# CITY OF PORTLAND BUILDING PERMIT

**PERMIT ID:** 2013-00351

14 SAUNDERS ST

has permission to **Interior renovations to each unit - electrical, plumbing, kitchens, insulation, replacement of 4 windows exterior siding etc**

1st Floor Plan
1/2" = 1'-0"

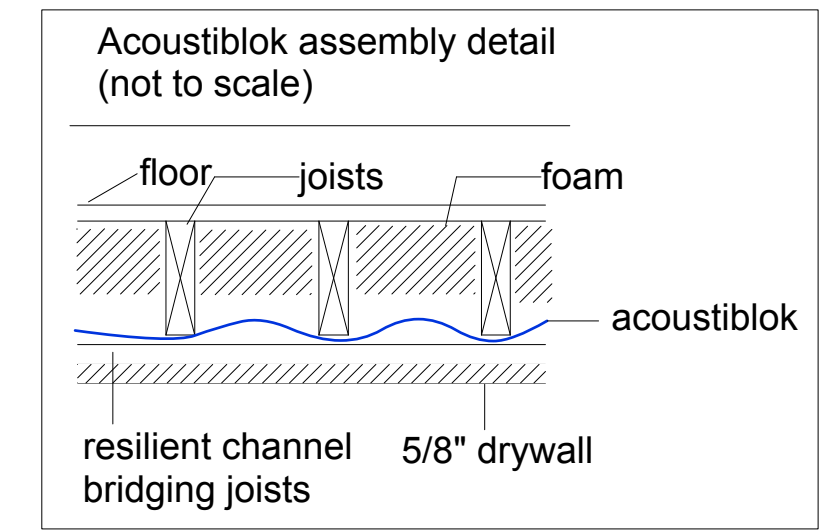
- 1) All ceiling coverings that are completely replaced that separate dwelling units or dwelling units and common areas are required to meet a 1 hour fire rated assembly and sound transmission rating of a minimum of 50 STC per the specified Acoustiblok product.

3rd Floor Plan
1/2" = 1'-0"

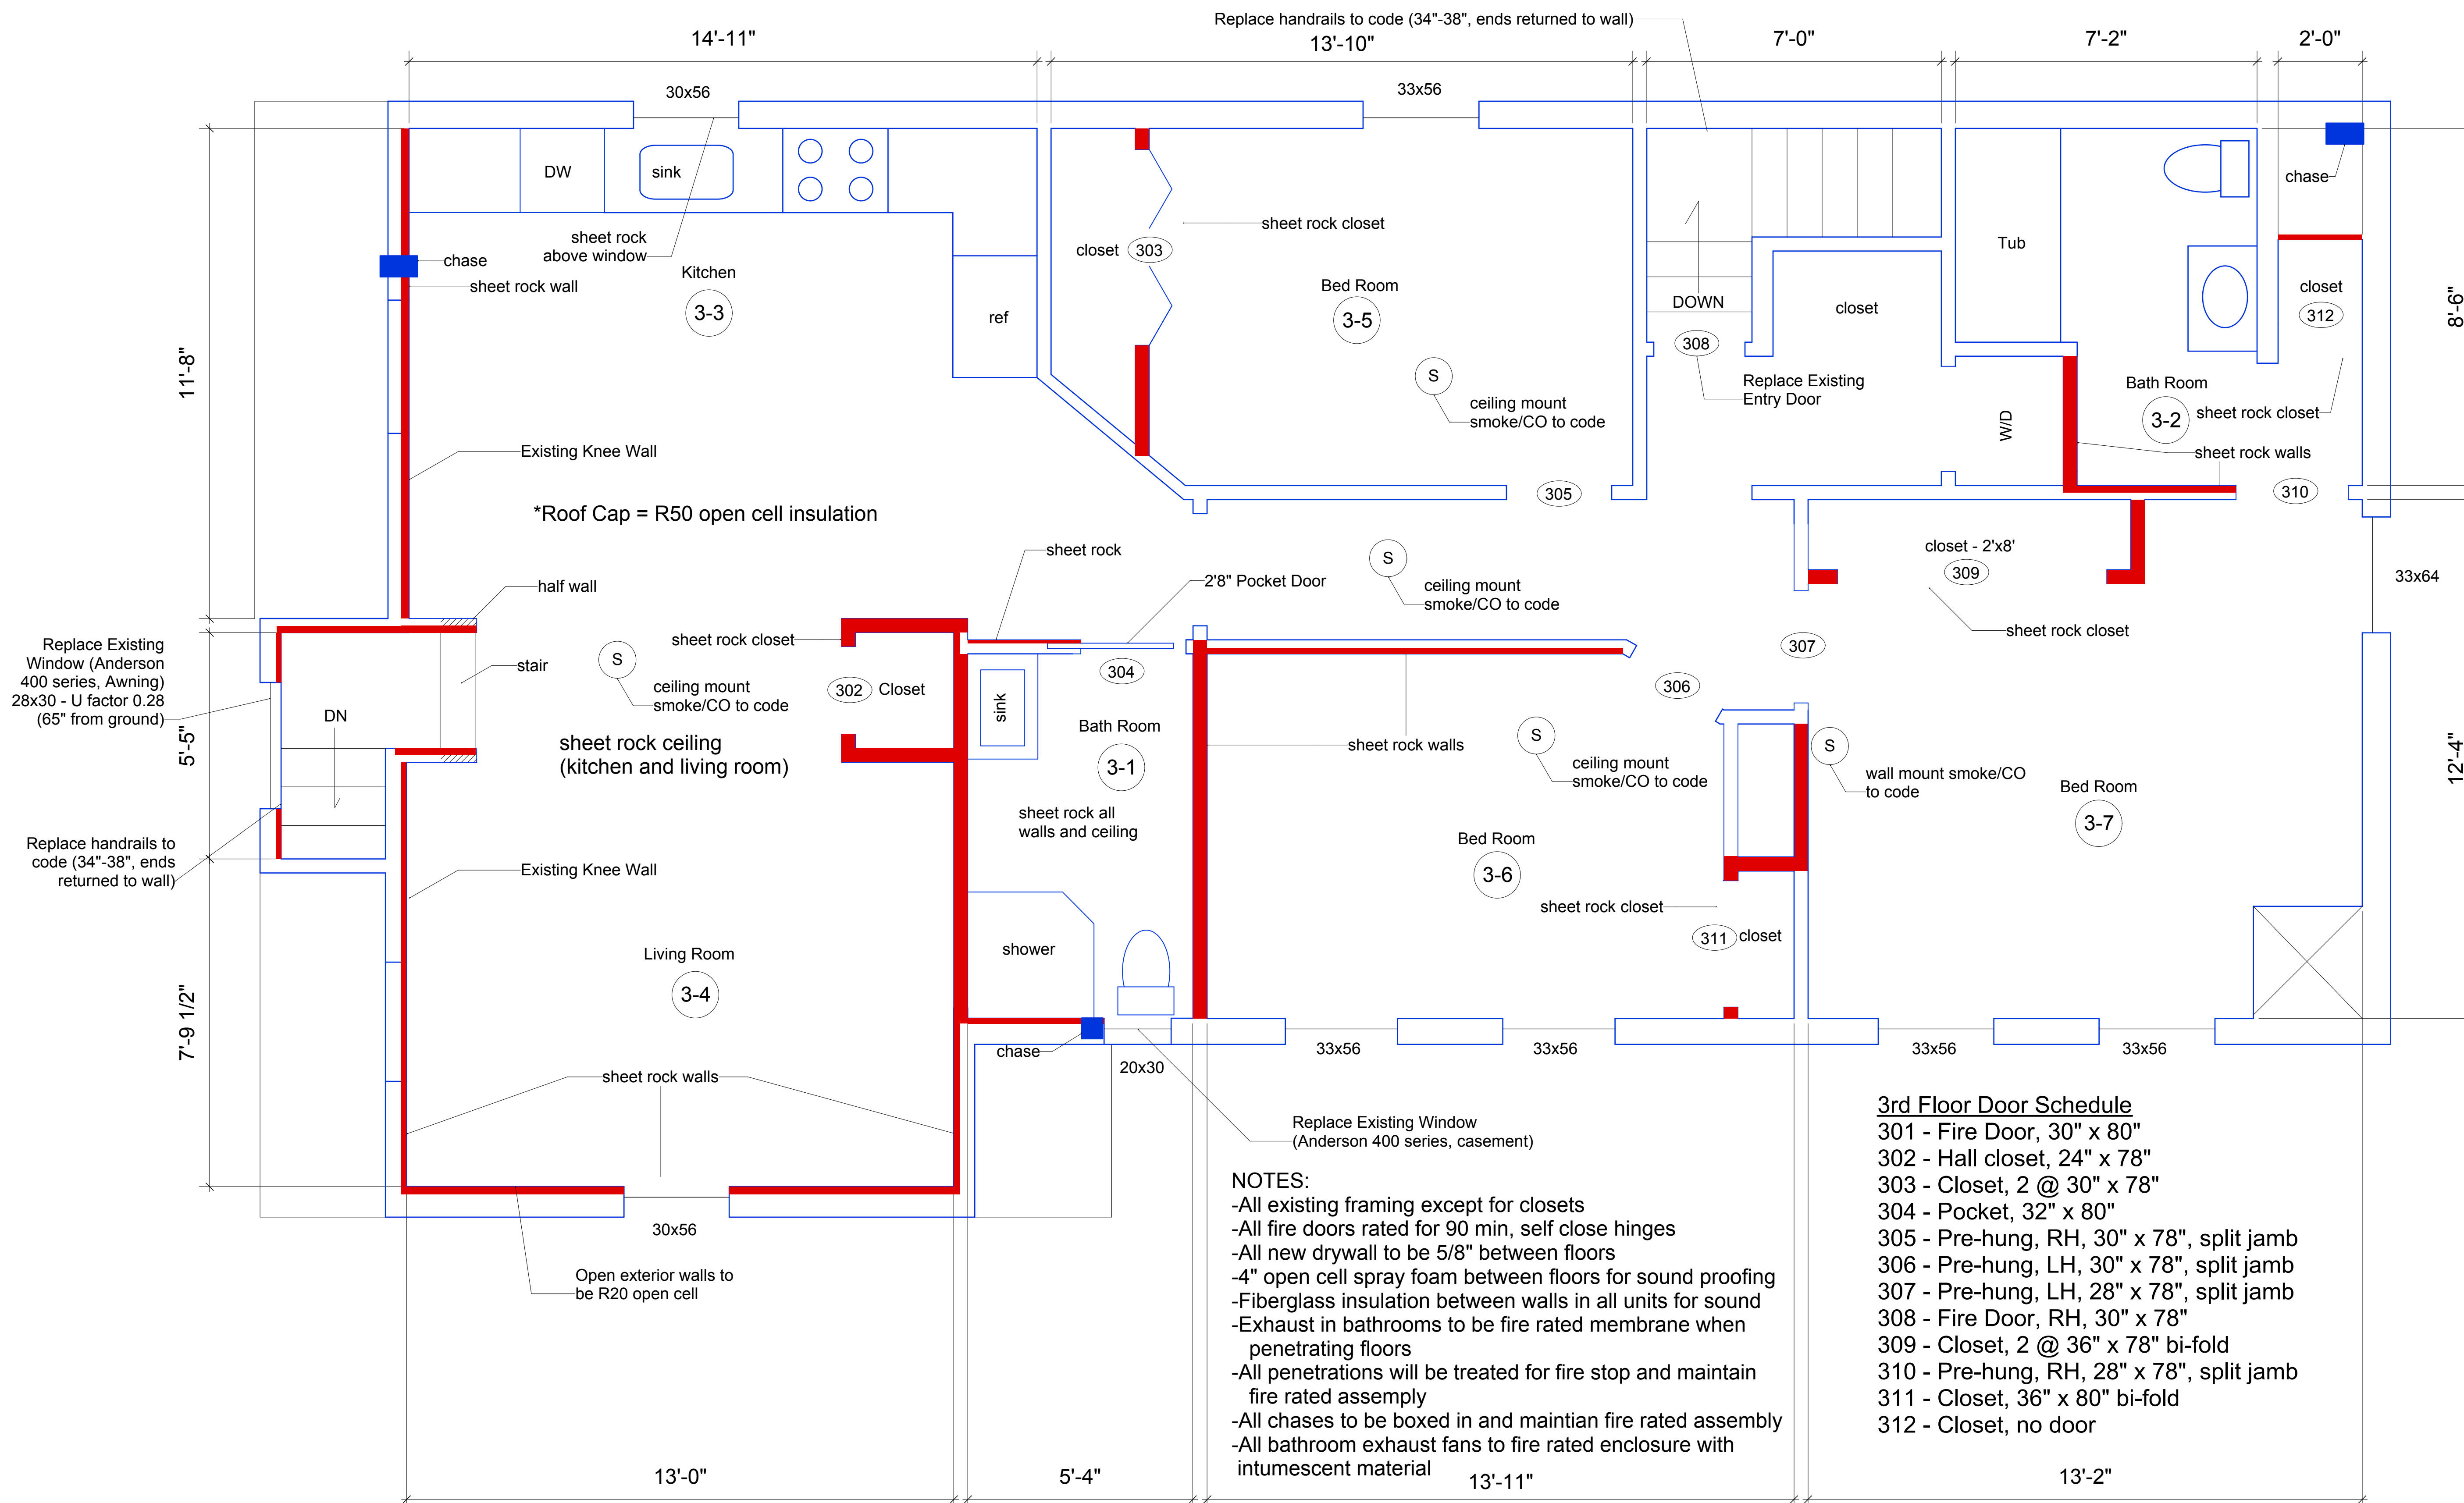
- 2) All penetrations between dwelling units and dwelling units and common areas shall be protected with approved firestop materials, and recessed lighting/vent fixtures shall not reduce the (1 hour) required rating per Sec. 713 of IBC and R317.3.1.2 of the IRC.
